from
**Southern
Water**

Our ref
DSA000006174

Proposal: Subdivision of the plot and construction of 3 detached bungalows with associated parking, access and landscaping (resubmission of CM/17/21/PL). This application is in CIL Zone 3 and is CIL Liable as new dwellings.

Site: CM/70/21/PL: - Land at Wren Cottage, Horsemere Green Lane, Climping, BN17 5QZ.

Proposed Site Plan

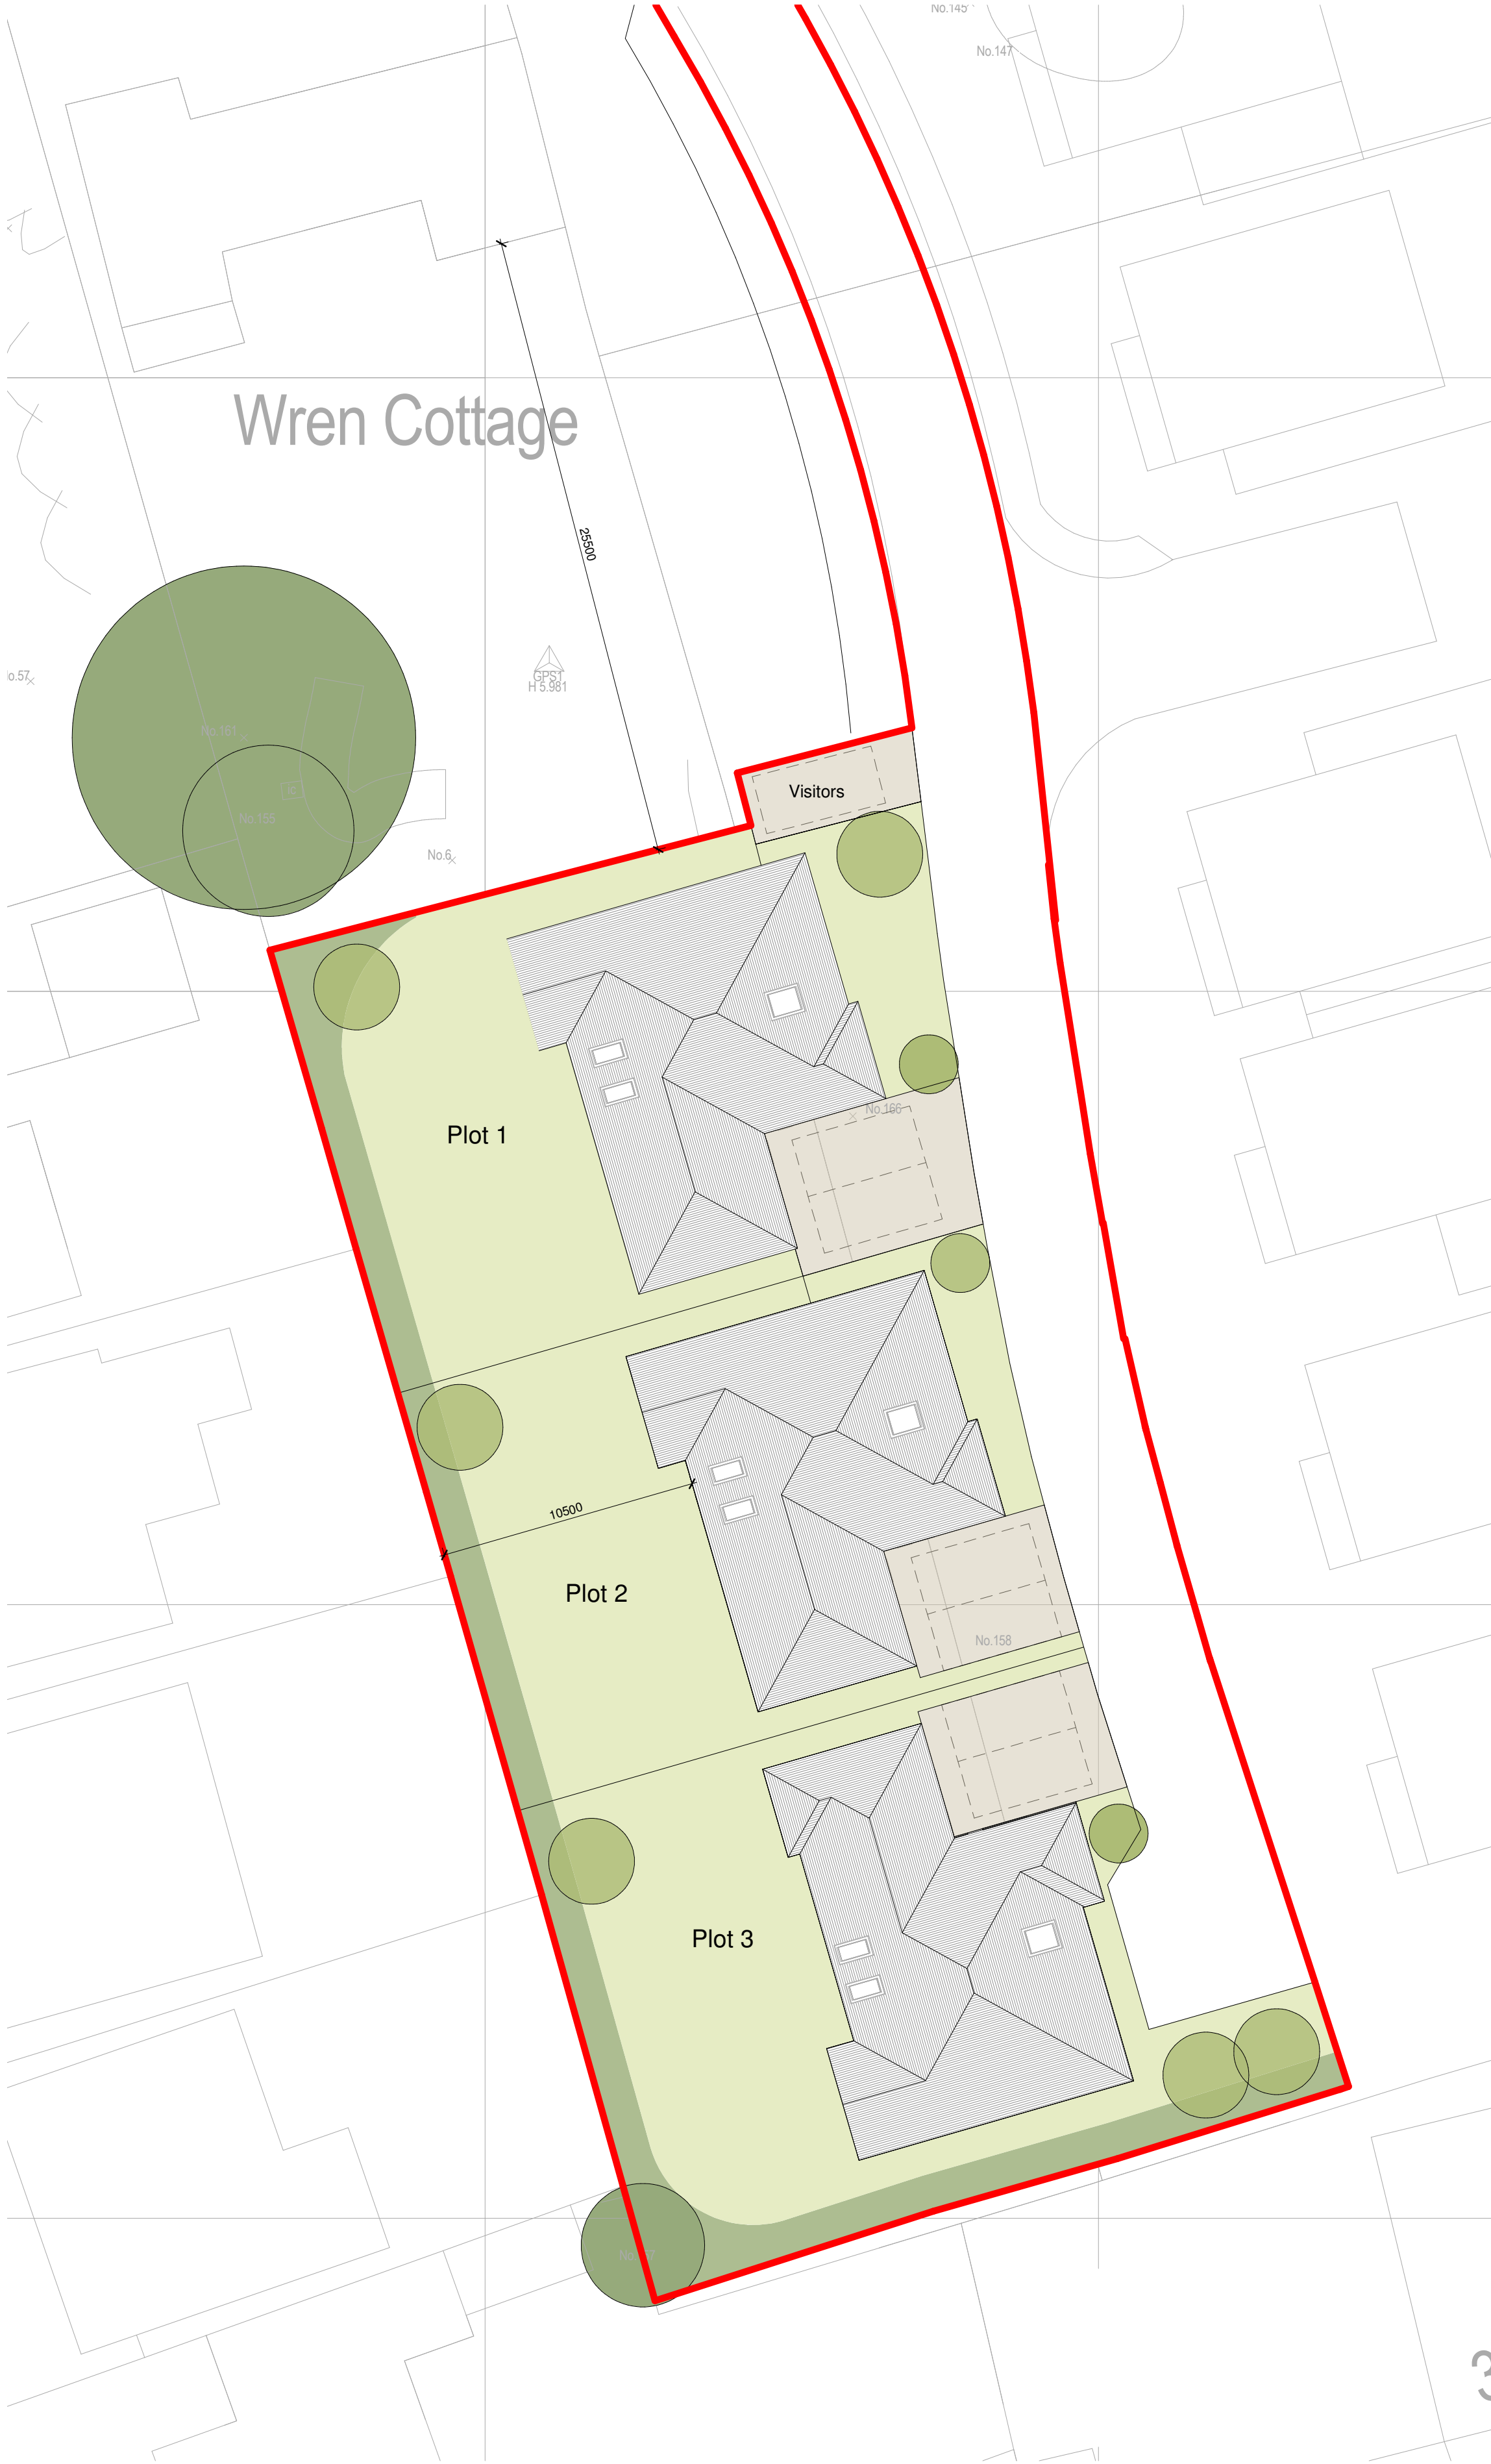
Please see the attached extract from Southern Water records showing the approximate position of our existing foul sewer within the access of the development site. The exact position of the public asset must be determined on site by the applicant in consultation with Southern Water.

- The 150 mm diameter gravity foul sewer requires a clearance of 3 metres on either side of the gravity sewer to protect it from construction works and to allow for future maintenance access.
- No development or tree planting should be carried out within 3 metres of the external edge of the public gravity sewer without consent from Southern Water.
- No soakaways, swales, ponds, watercourses or any other surface water retaining or conveying features should be located within 5 metres of public or adoptable sewer.
- All existing infrastructure should be protected during the course of construction works.
